## SUBMISSION 2: SUMMARY OF ADDITIONAL CONCERNS IN RELATION TO THE PROPOSED NORTHCONNEX TUNNEL

Application number - SSI 13\_6136

MOTORWAY OPERATIONS COMPLEX - SOUTHERN VENTILATION FACILITY - SECTIONS
M1-M2-5000-DR-JD-0525

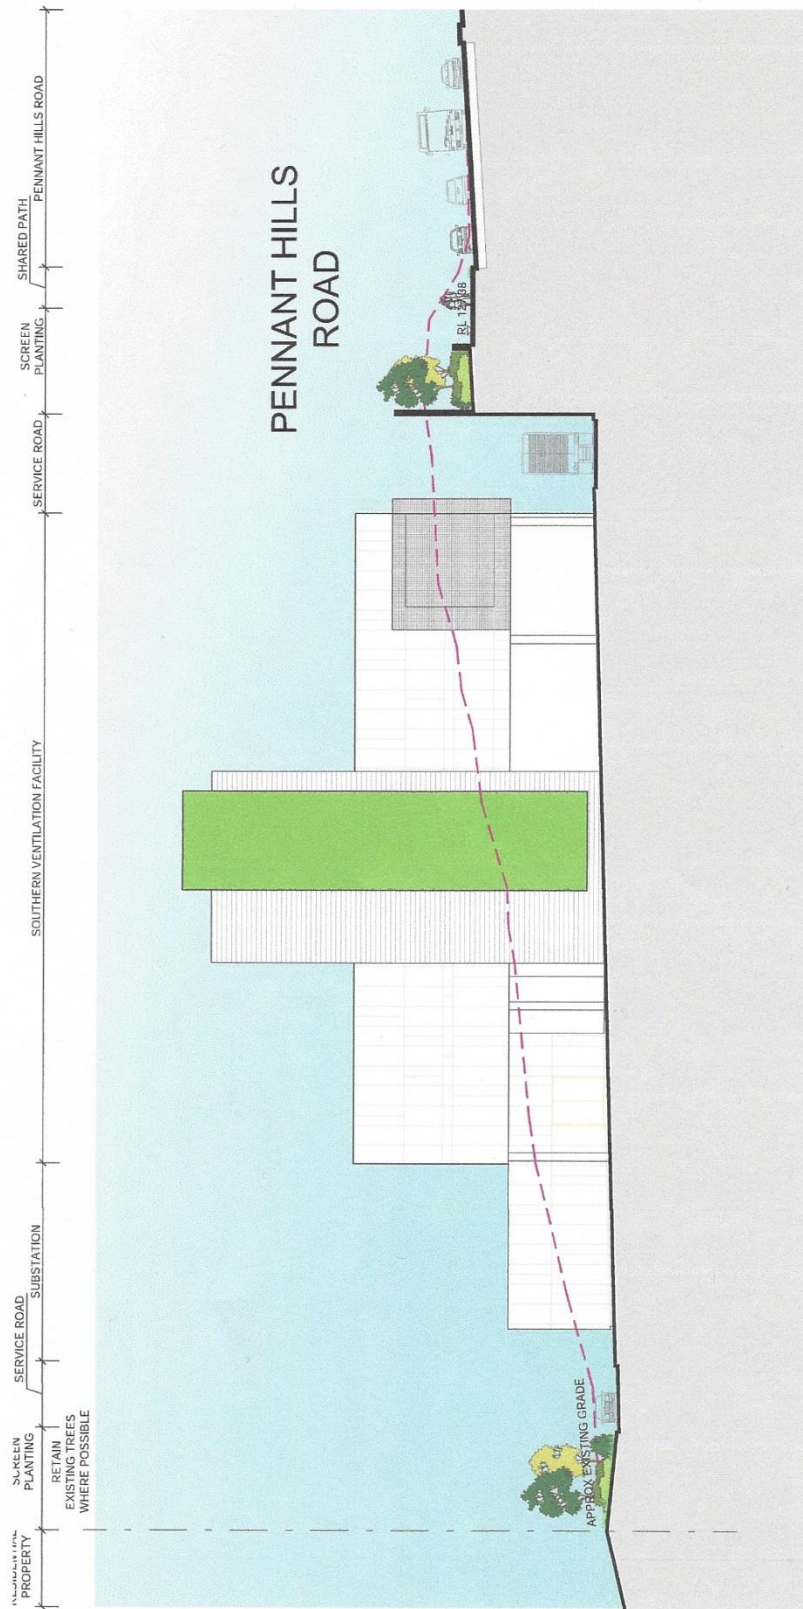
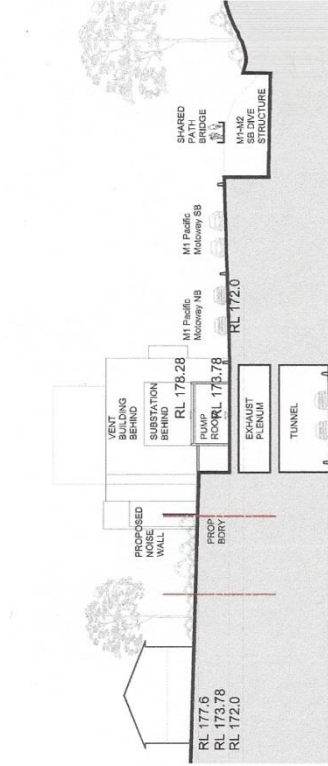
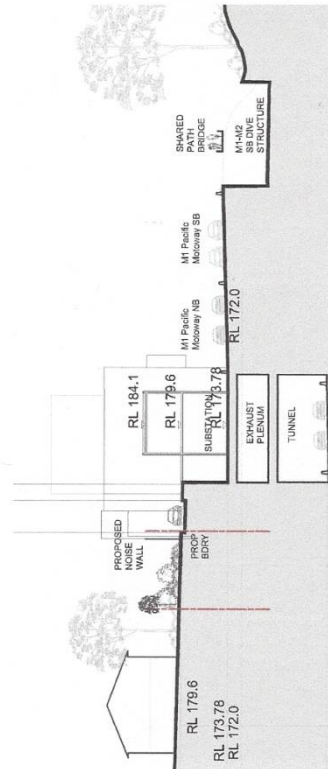
Speakers at the NorthConnex Air Quality Forum spoke of the importance of the topography in the placement of the ventilation facilities. In the NorthConnex proposal the southern ventilation facility is at the lowest point of the M2 intersection where it is surrounded on three sides by hillside cuttings. In this location the “discharge point” will barely be above the adjacent high ground.

Much is made of the intention to discharge the polluted air through the stack at 13 – 19m/s. Given that the stack is only 15m above Pennant Hills Road, a simple calculation indicates that the particles will be ejected to a height of between 23m and 33m above Pennant Hills Road. That will only be sufficient for them to be dispersed by prevailing winds IF there is wind and it is strong enough. For instance, the weather history graph showing the wind speed and direction at West Pennant Hills measured on the 24th August 2014 indicated that there was no wind until 9am and what wind there was, came from the west. Wind speeds of less than 2m/sec (ie about 8km/hour) are not considered sufficient to disperse pollution from the stack. Only a very few gusts on this day were in excess of 8km/hour.

That the Government ensures that the southbound ventilation facility ie the Stack, be located at the south-west corner, on the RMS owned land, at the edge of the Pennant Hills Golf course. In this location, the southbound tunnel can be efficiently, effectively and economically ventilated.

The impact of the stack plumes on the surrounding residential areas must be modelled using its current proposed position and height and also modelled with the stack positioned on the golf course side of Pennant Hills Road, where it is topographically higher. This would allow an objective, impartial, scientifically based assessment to be made of the most effective location for the stack.
